From: Samantha Allen
Sent: 02 October 2018 11:40
To: Planning.Responses
Subject: FW: AW/210/18/HH - 1 Raycroft Close

PLAN 1-100

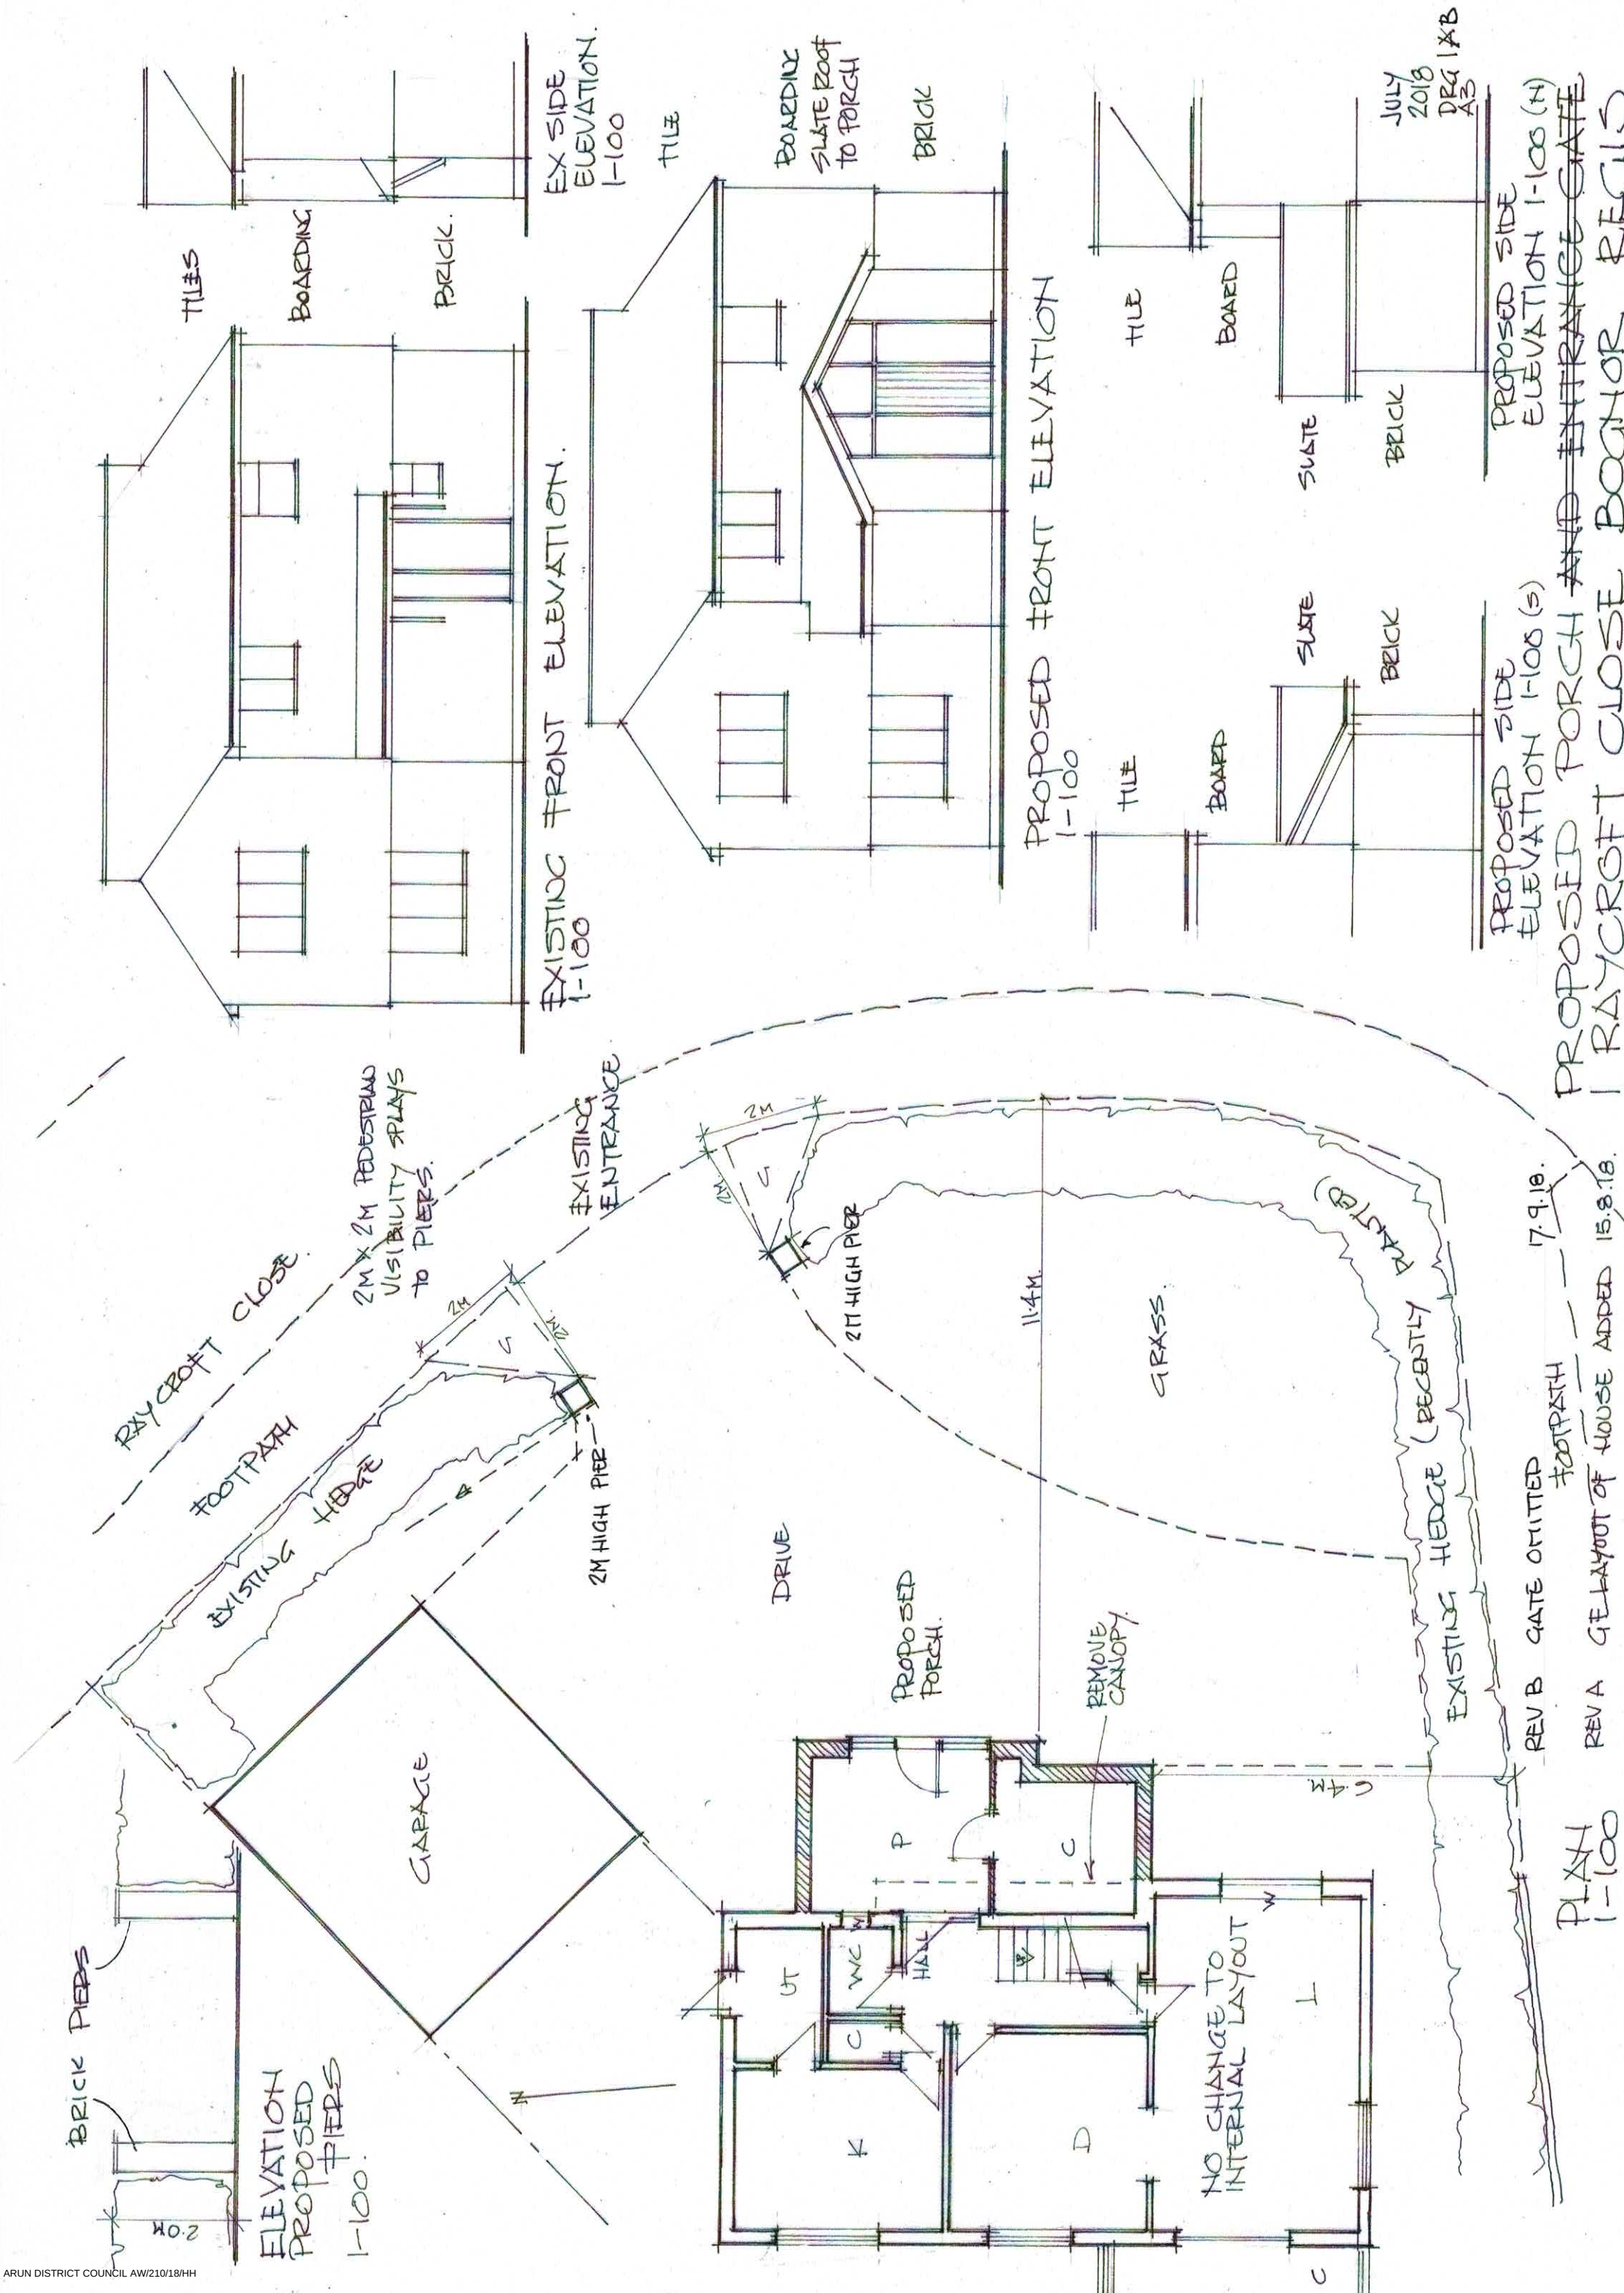
Further to your revised plan I have received a query from the Parish Council about the fact that the brick piers are still showing on the drawing. Could you please advise whether you still wish for these to form part of the application? I do not need another drawing thank you, just confirmation please.

No they are not required.
